**Arrangements for Handling Heritage Applications Direction 2021 & Planning
(Listed Buildings and Conservation Areas) Regulations 1990**

**George Hotel, St George's Square, Huddersfield, HD1 1JA
Application No. 2026/65/91370/W**

Historic England consider that the proposed temporary stair would cause a less than substantial amount of harm to the significance of The George Hotel, a nationally significant Grade II* listed building.

4 Level 04 - Haki Stair Demolition Plans
1 : 100

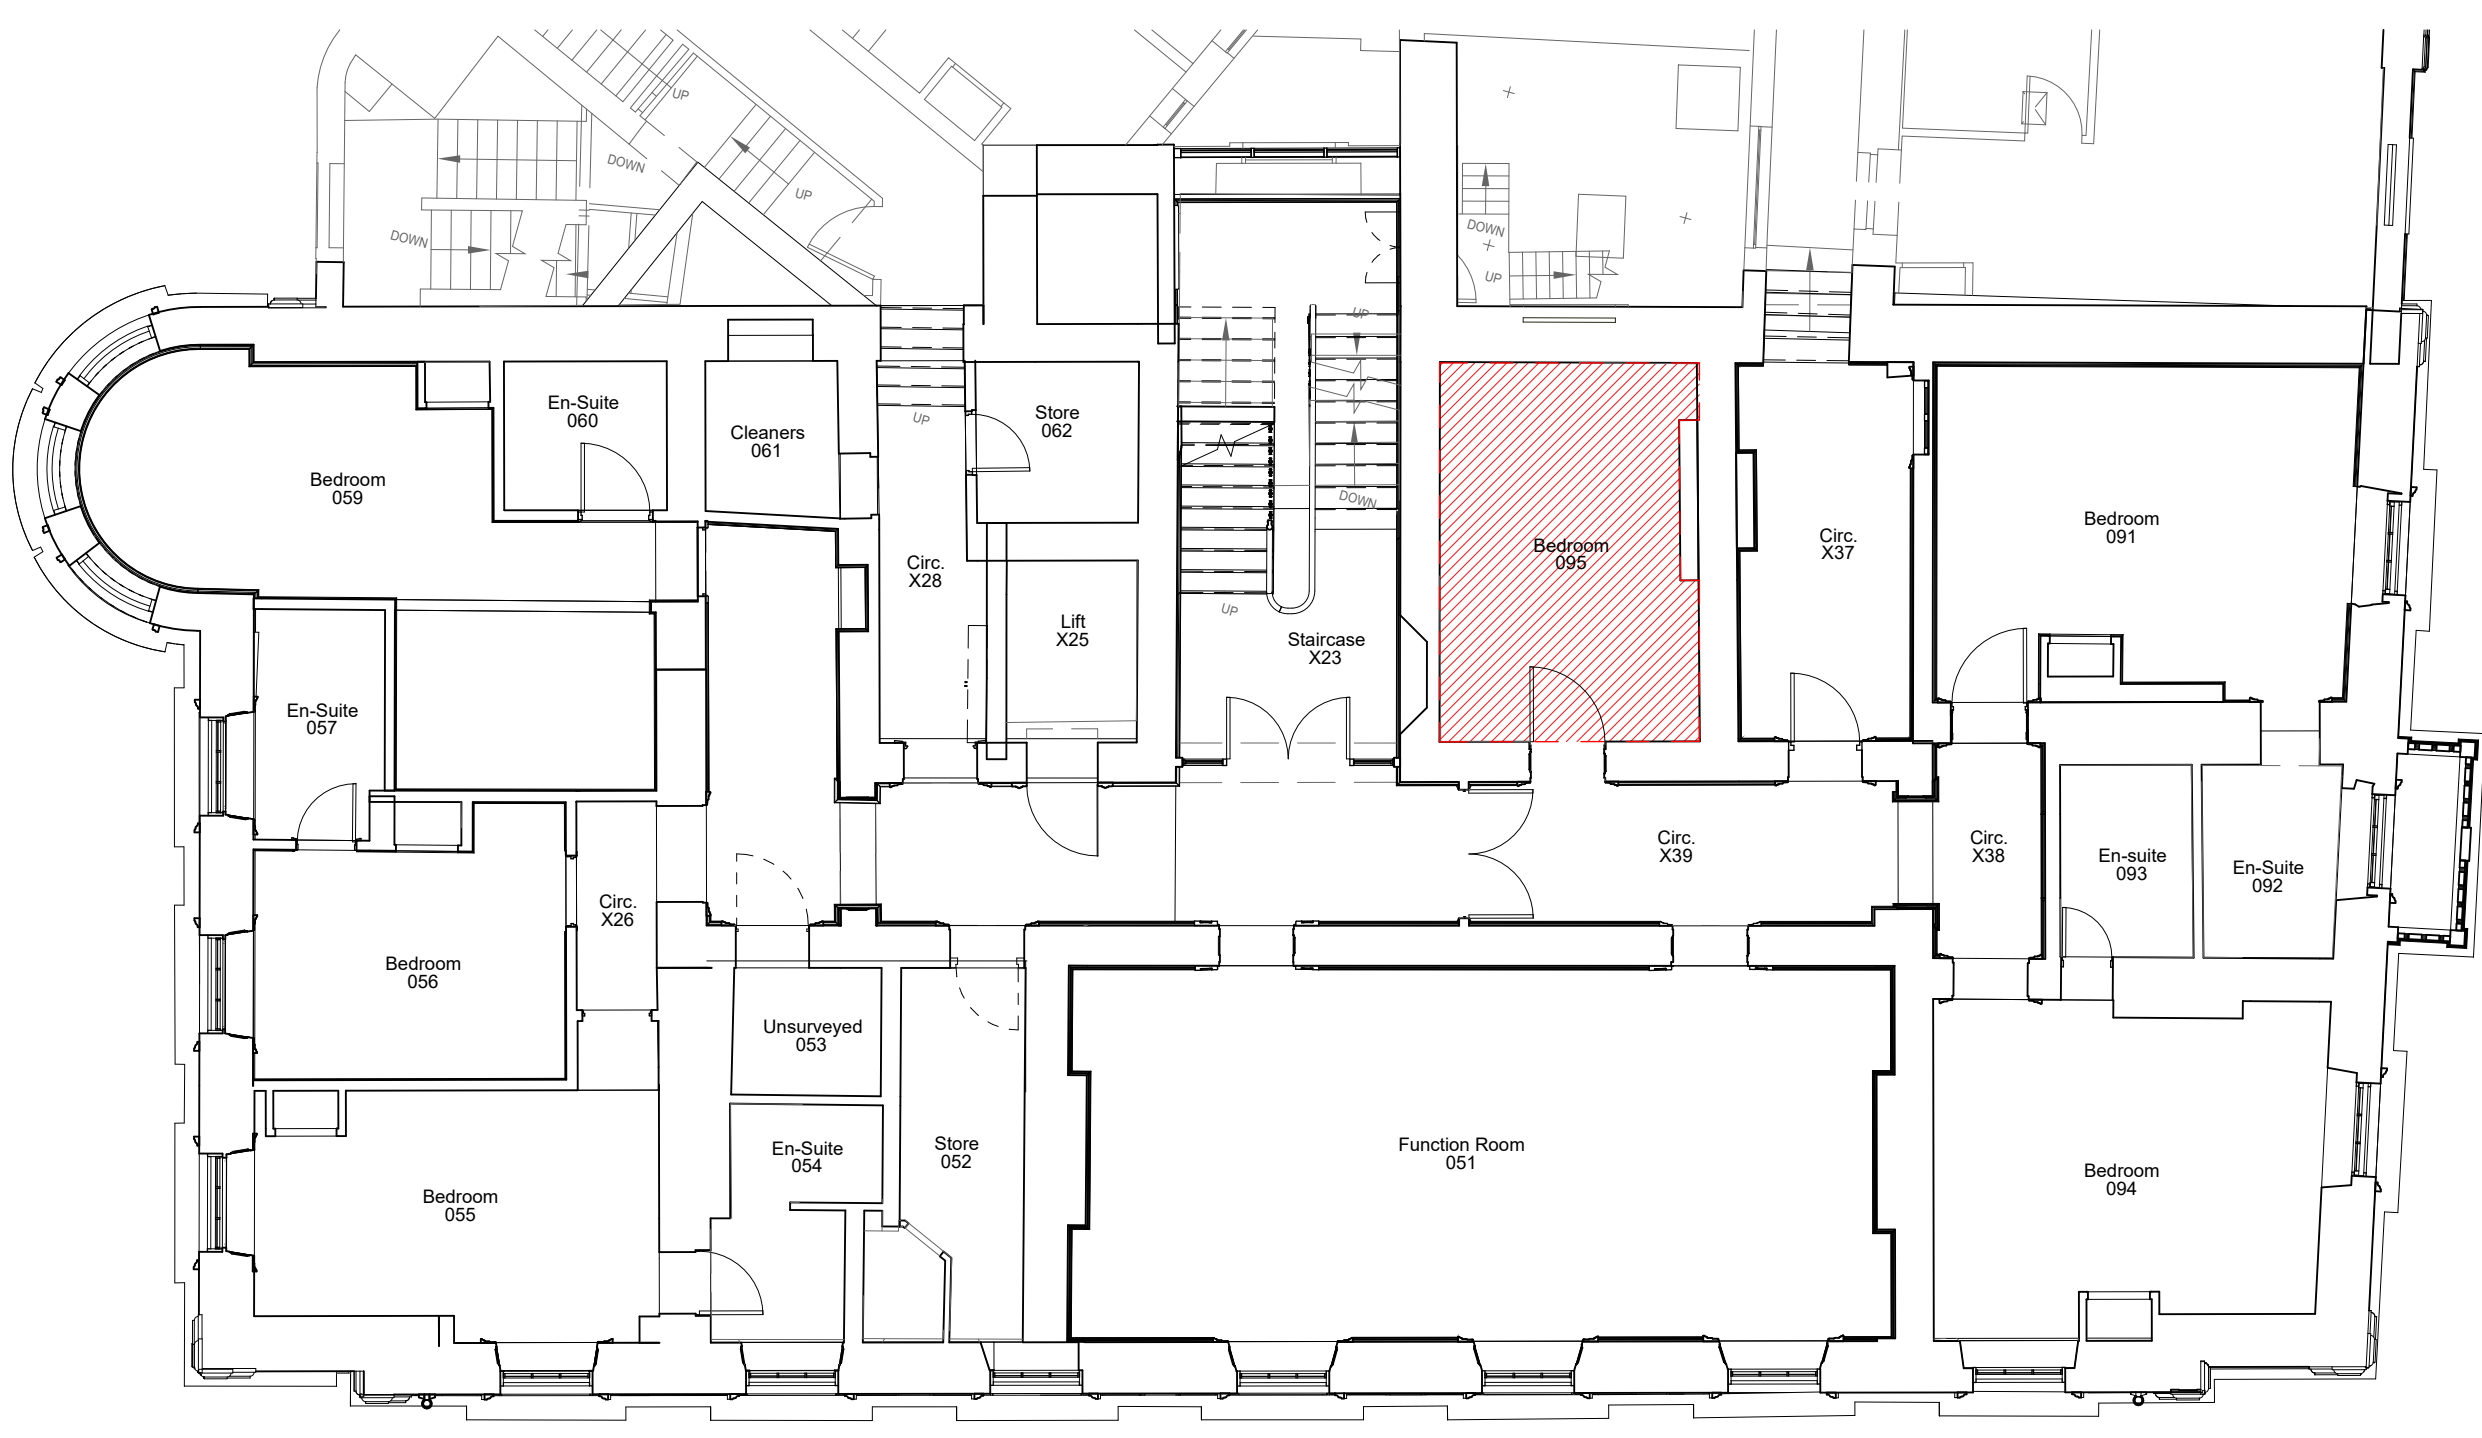
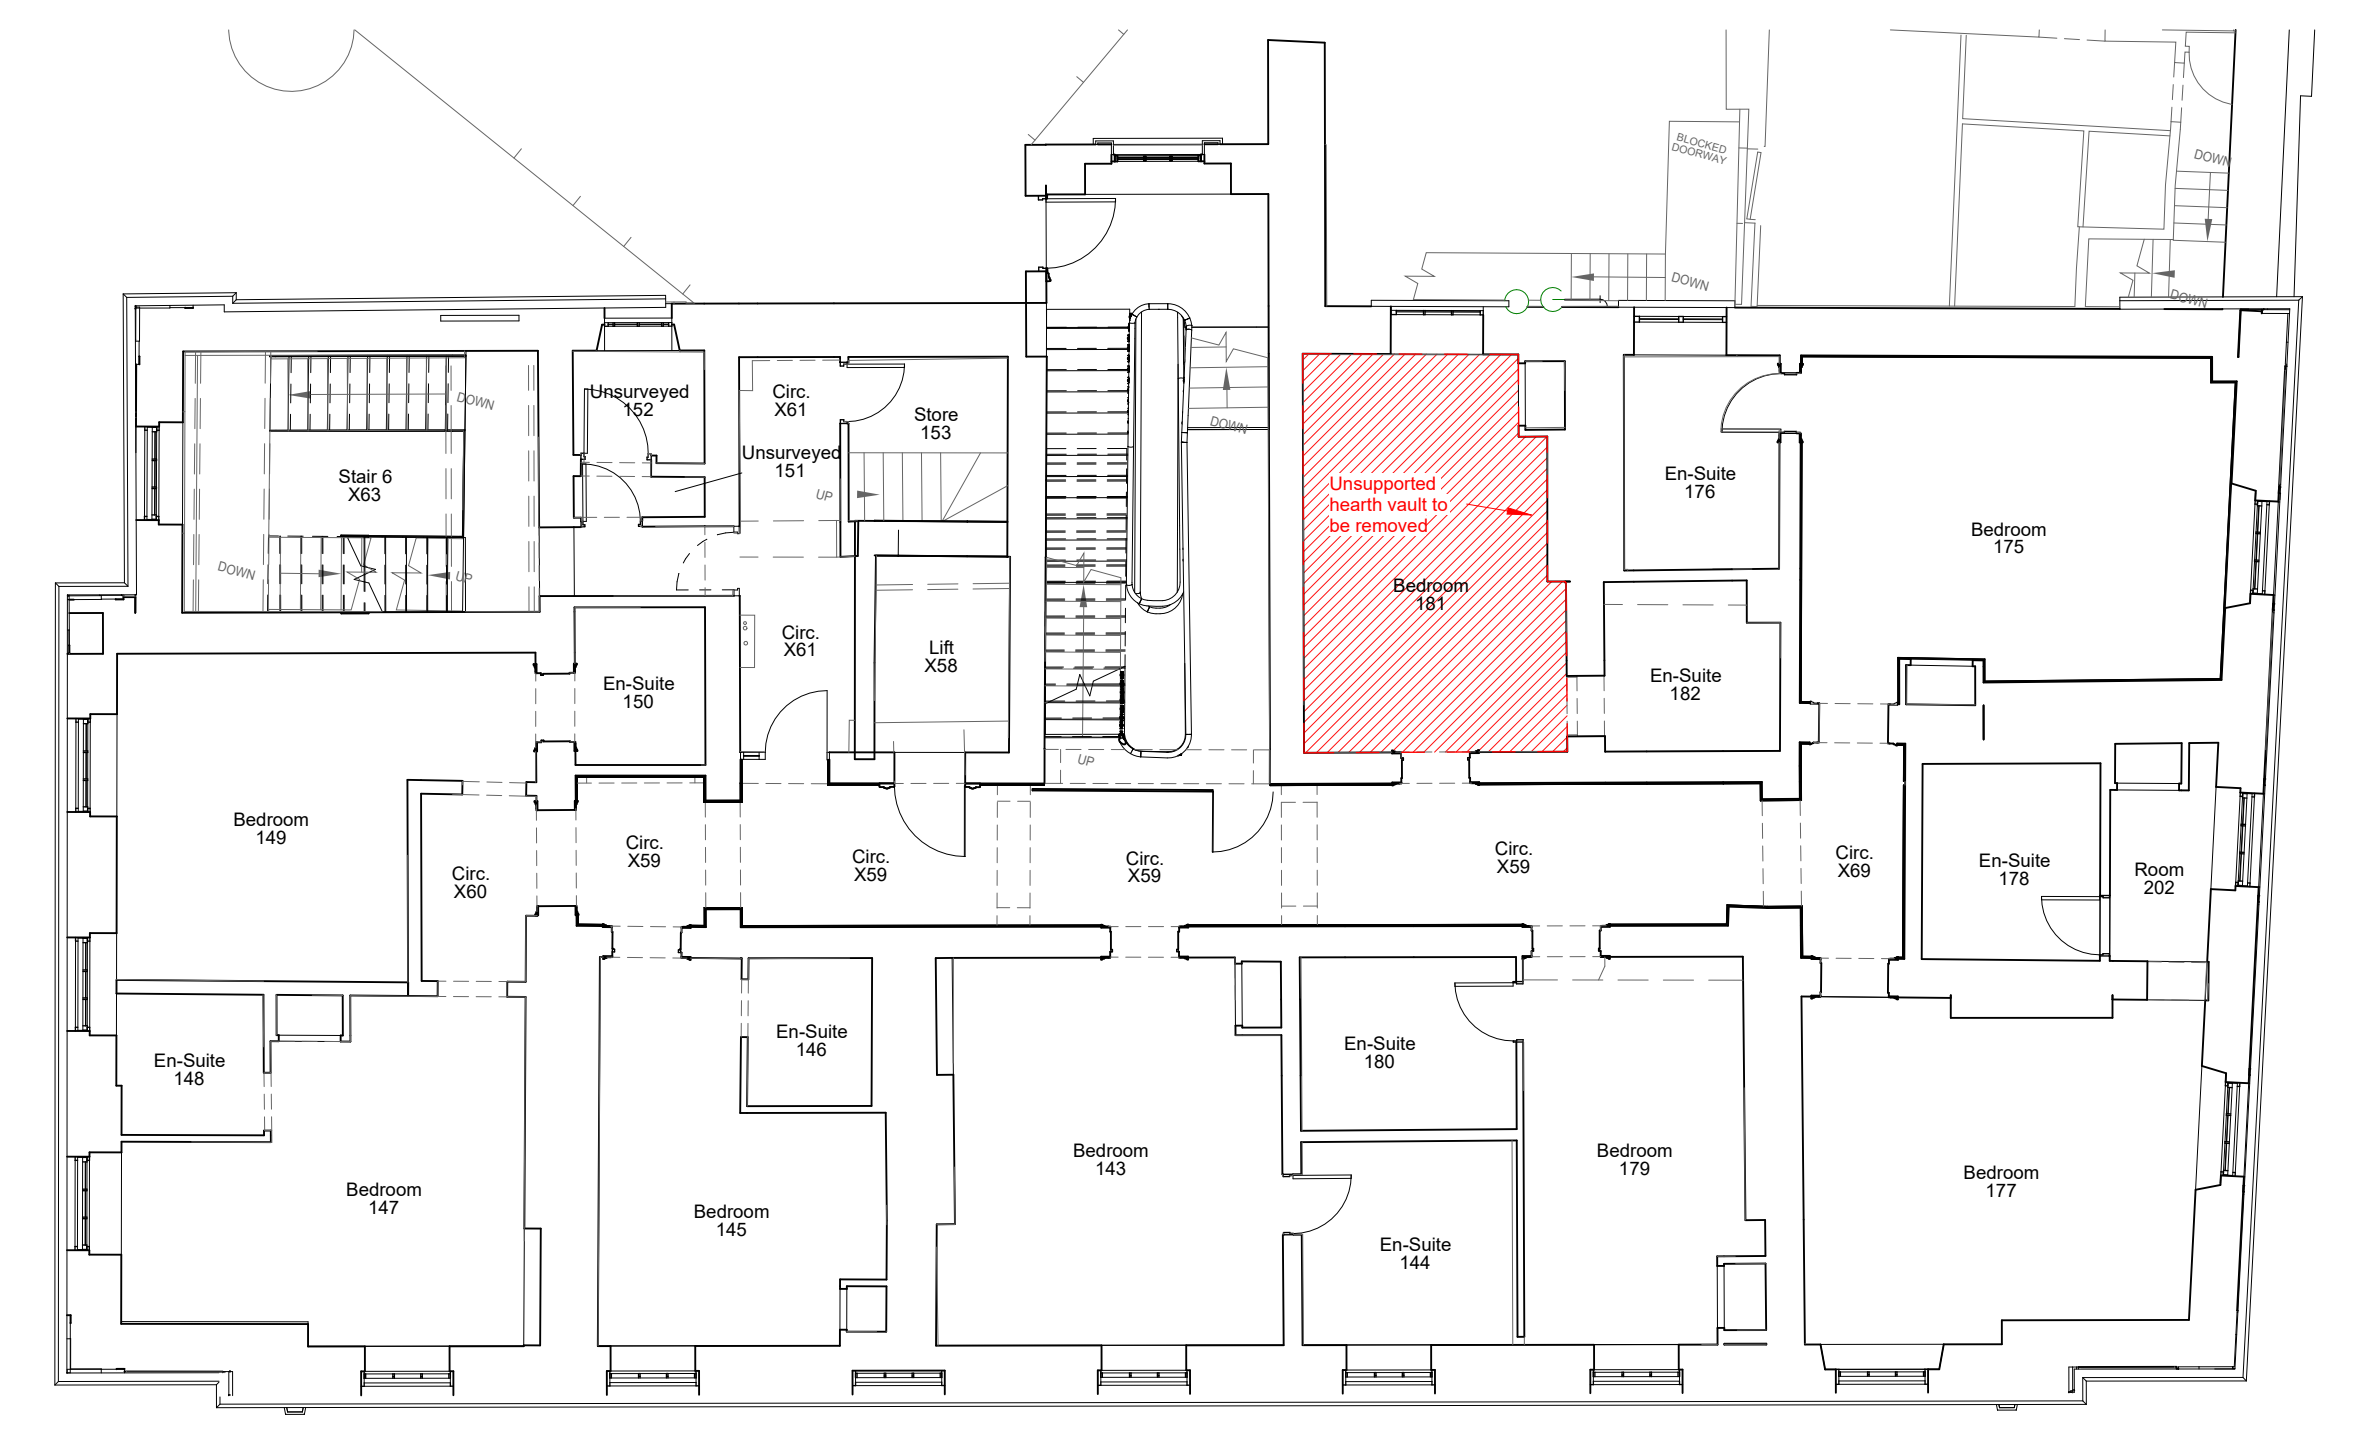
The proposed temporary service stair would lead to the physical harm to historic fabric across all floors.

This harm is isolated to one room in which a section of floor boards and joists would be cut out. This is considered to cause a less than substantial amount of harm the significance of The George Hotel through the loss of historic fabric.

It is proposed to reinstate the floors which will minimally mitigate the identified harm above.
